# Consultee Comment for planning application 6/2024/1342/RM

| <b>Proposal</b>           | Approval of reserved matters (appearance, landscaping, layout, and scale) following outline planning permission S6/2015/1342/PP as varied by 6/2023/1352/VAR for residential development of 10 dwellings and associated infrastructure  |
| <b>Organisation</b>       | Hertfordshire Constabulary  |

Illustrative Street Elevation - Front

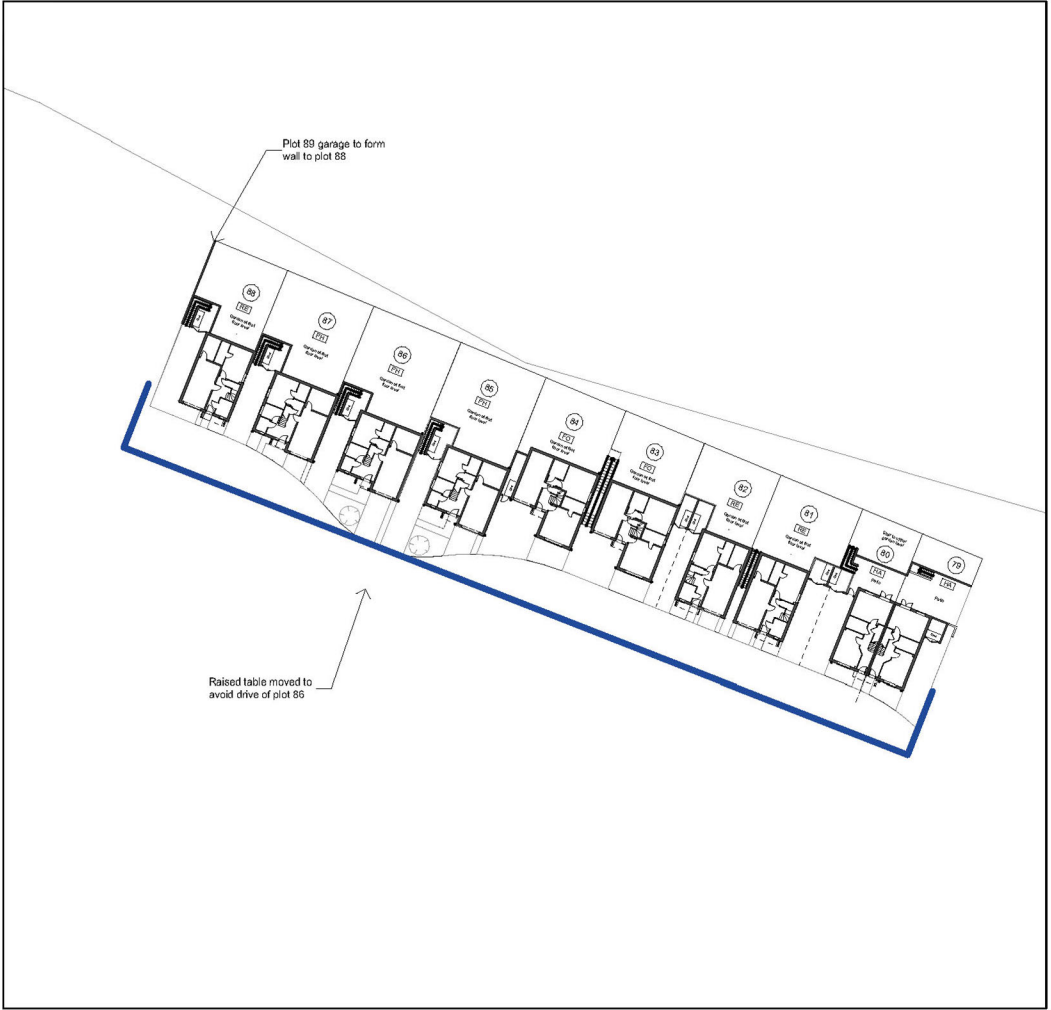
| <b>Comments</b>           | Thank you for sight of this application on which I have commented from a safety and crime prevention perspective on previous occasions in a positive manner. My only concern with this particular application, relates to the lack of defensible space to the front of some of the new plots. The front lounge windows is a few of the plots are very close to the public path. I note indicative planting in an effort to provide some 'push-back', which will help. I would ask that more mature planting of one (1) metre high hedge be used to provide the maximum visual effect. Other than this issue, I am more than happy to support the application. |
